M25 junction 28 improvement scheme

TR010029

9.55 Written submission of Applicant's case put orally at Issue Specific Hearing 1 on Environmental matters held on 3 and 4 March 2021

Client	MR L JONES & MRS K JONES			
	FOR APPROVAL			
Project	GROVE FARM ACCESS, JUNCTION 28 M25 NORTHBOUND SLIP LANE			
	SUGGESTED ALTERATIONS TO GROVE FARM HIGHWAY ACCESS			
Status	Drawn	PL	Scale	1:500
Sheet Size	A3	Date	JAN 2021	Rev
Drawing No.	REDW-3396-111			Rev

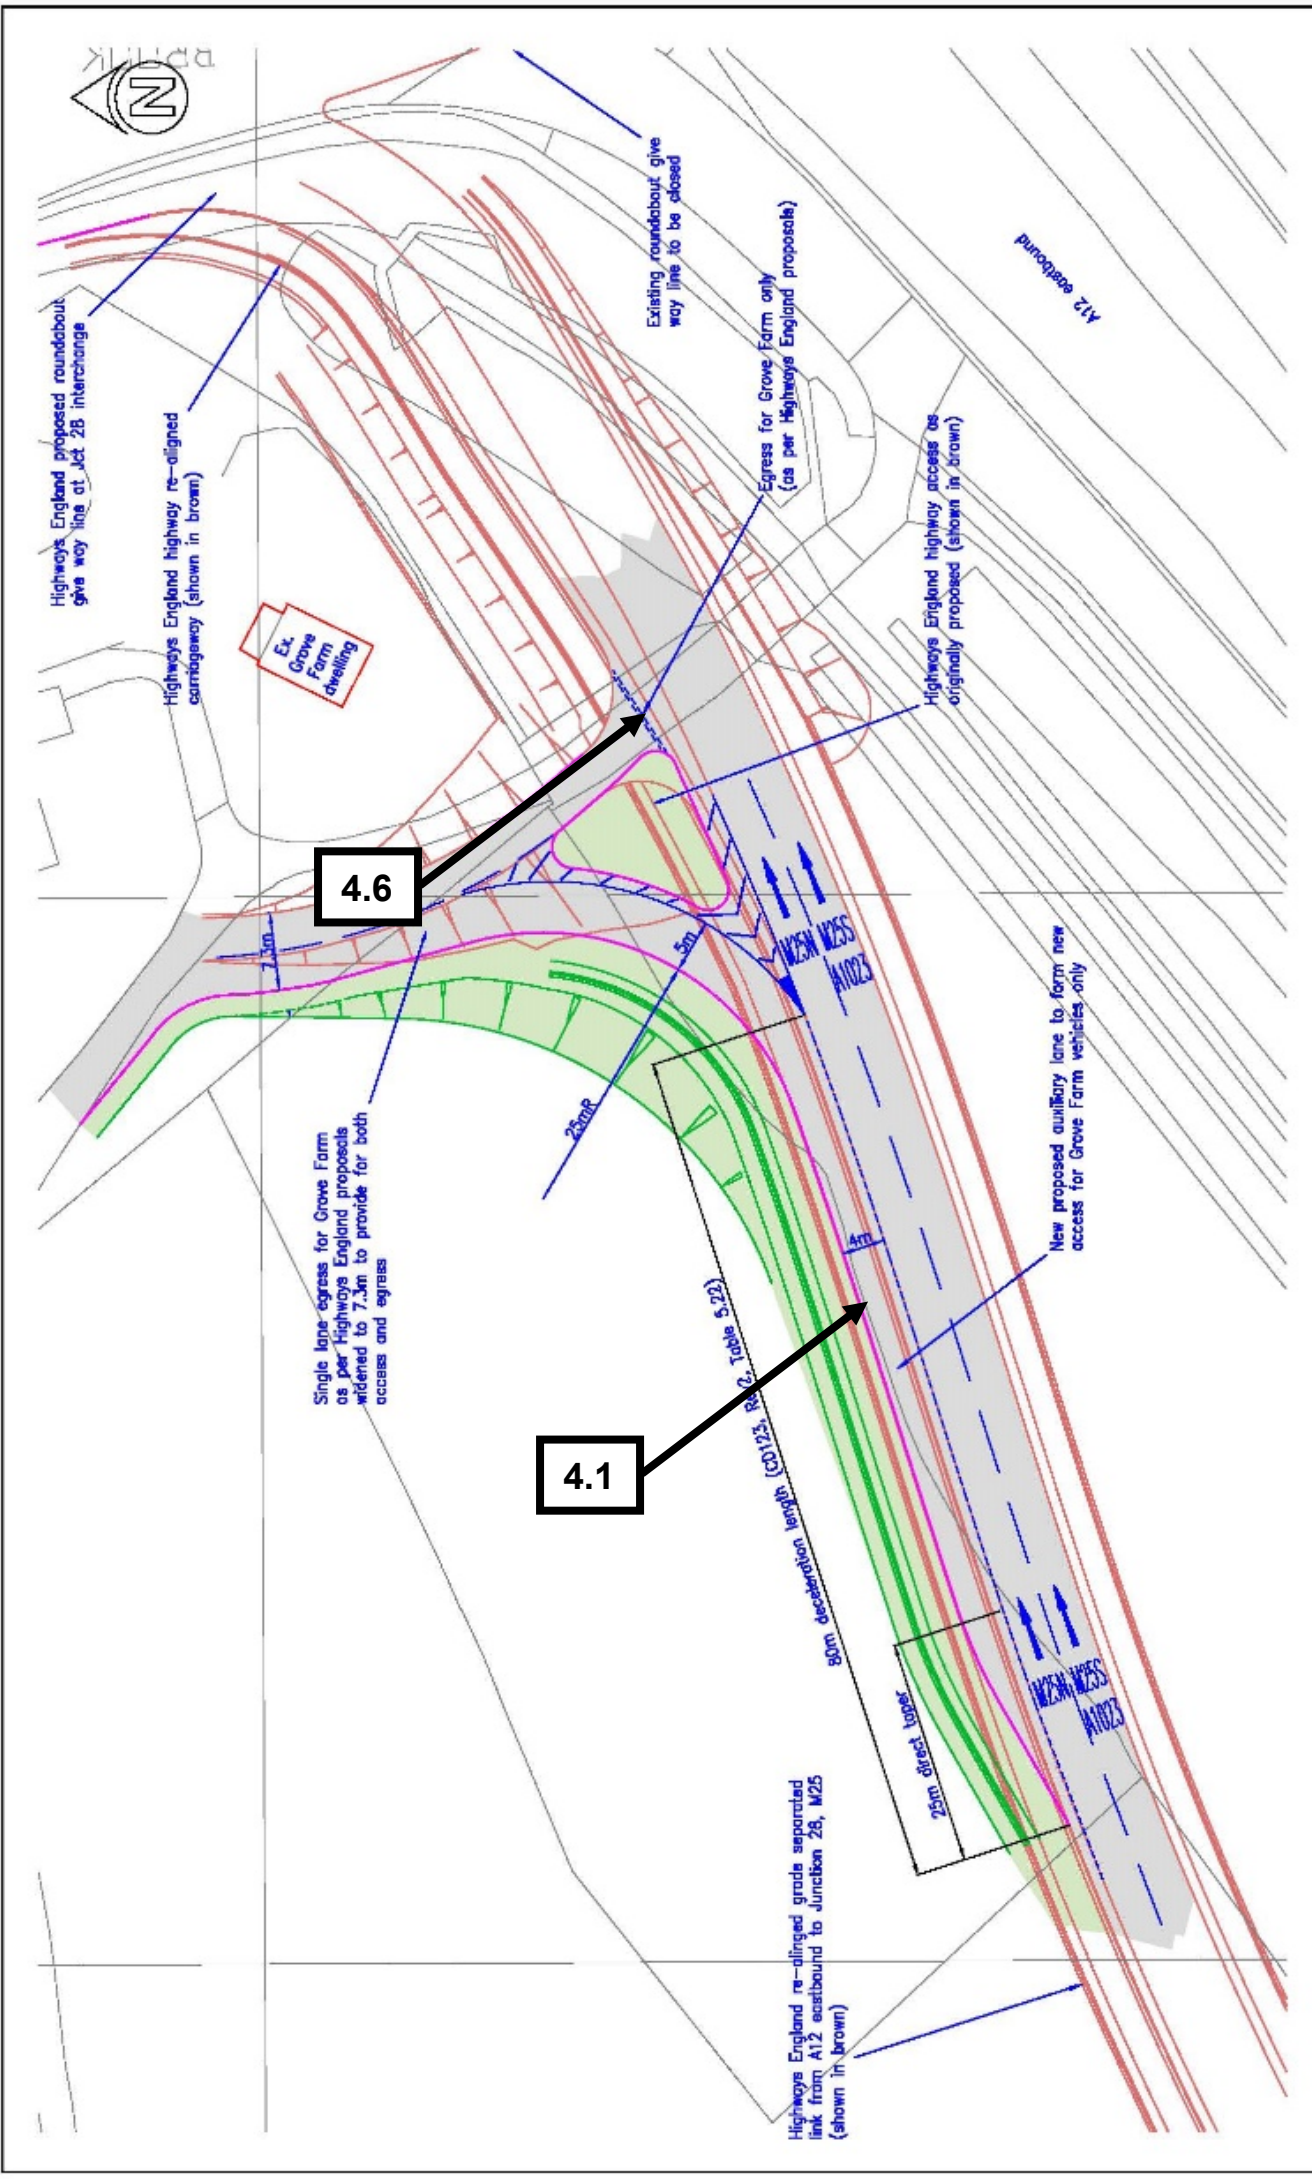
Agenda item 2.6 - Suggested alterations to proposed access to and egress from Grove Farm prepared by representatives of the Jones Family submitted at Deadline 2 [REP2-033].

- 3.1.59 Relocating the ingress further north along the M25 on-slip road places it where highway vehicles are accelerating towards the merge with the M25. SH explained that Highways England's road safety and operational safety specialists had raised concerns that such a relocation would be unsafe as vehicles braking to enter Grove Farm may cause collisions with vehicles accelerating to the M25. They also raised concerns that vehicles may exit Grove Farm via the ingress and turn right onto the slip road resulting in head-on collisions.

- 3.1.62 SH explained that a new ingress from the A12 would introduce an additional movement. This would create further hazards for through traffic as vehicles brake for the diverge where slip road traffic is travelling faster being further way from the stop line. This level of provision for a private access could also be confused with the M25 on slip. SH noted again that the Highways England's road safety and operational safety specialists have raised concerns that such a provision would be unsafe.

- 3.1.63 SH acknowledged that TfL had stated this and confirmed that direct accesses on slip roads are not permitted in the design standards. They would be departures from standards. Operational safety would be a material consideration in the departure approval review

- 3.1.64 SH concluded that moving the revised access from the M25 slip position as proposed by Grove Farm is less safe because vehicles are increasing their speed to merge with the M25. The existing access is close to roundabout so vehicles would be moving slowly.
